Sea Link Energy Cable

**Natural England's Comments on Kent Landfall**

Planning Inspectorate Reference EN020026

19<sup>th</sup> January 2026

Figure 1-1 Application Document 2.13.2 Design and Layout Plans – Kent Indicative Horizontal Direction Drill Solution Pegwell Bay [APP-037].

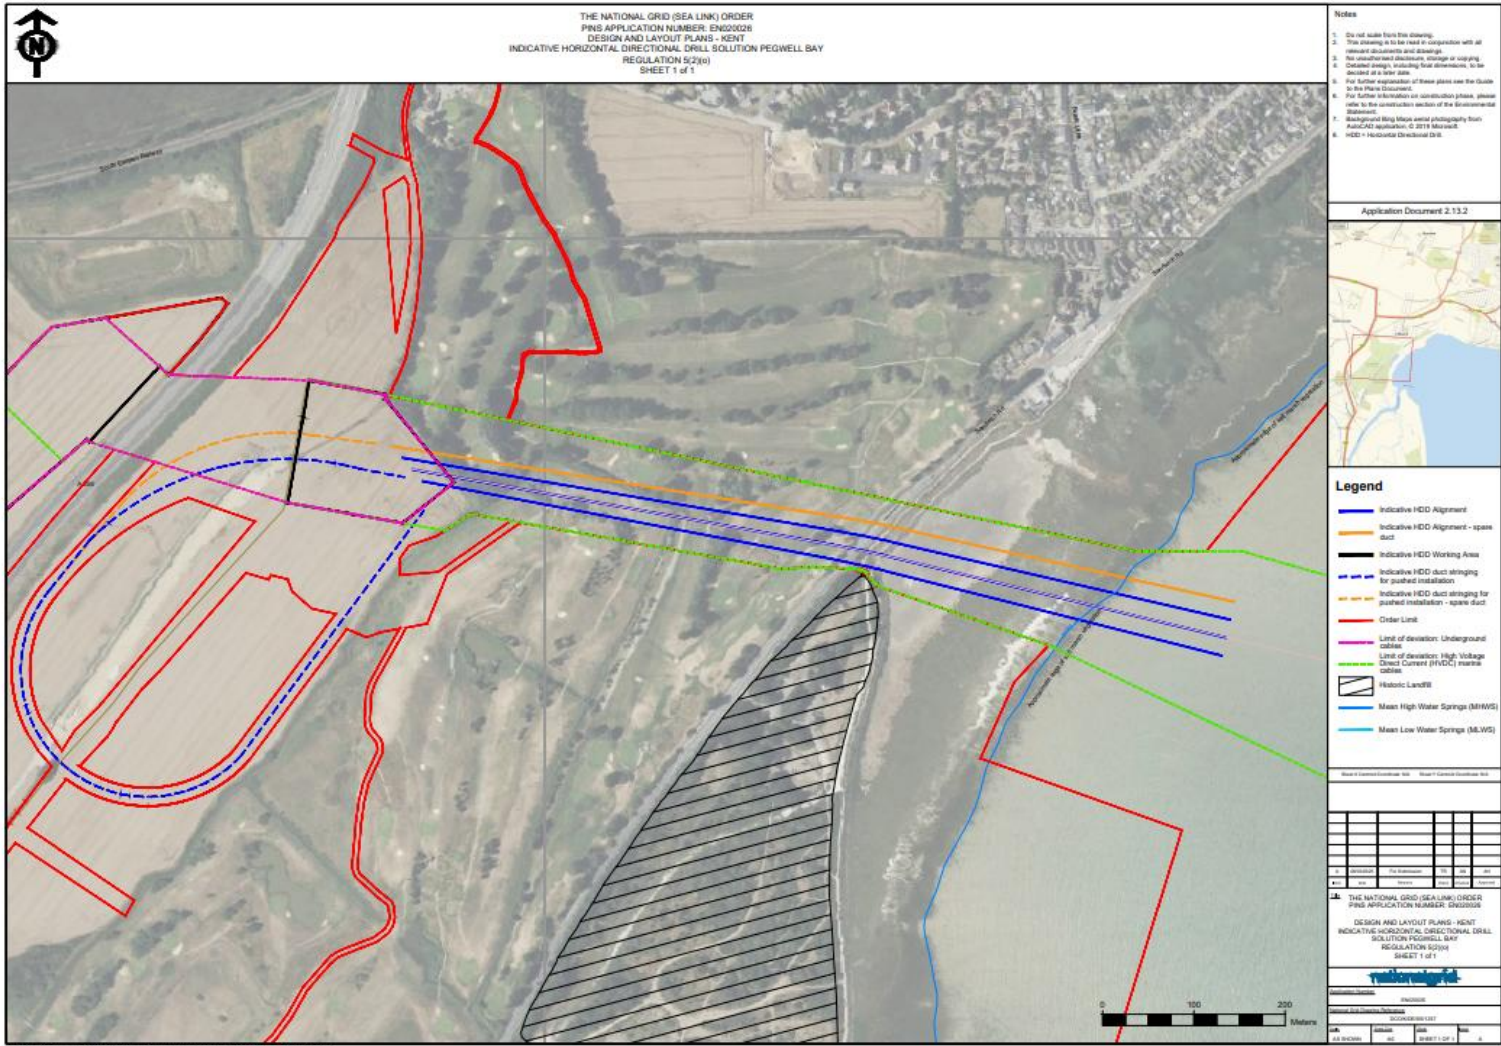
| Document reviewed: AS-007 6.6 (B) Habitats Regulations Assessment Report. |         |   |   |
|---|---------|---|---|
| 3   | 4.3.4   | Natural England notes that assurances are made by the Applicant that a distance of 105-140m between the exit pits and the saltmarsh is sufficient to avoid damage. However, we also note that the working area is only 50m away from the saltmarsh. There is also no consideration of: <ul style="list-style-type: none"> <li>the coastal process impacts from having cofferdams in situ for 120 days.</li> <li>saltmarsh accretion and the implications for operational activities should exit pits no longer be located outside saltmarsh habitats</li> </ul> | Natural England advises that further consideration is required in relation to potential impacts from changes in coastal processes from the presence of infrastructure during installation and possibility of changes in extent of interest features over time.                      |
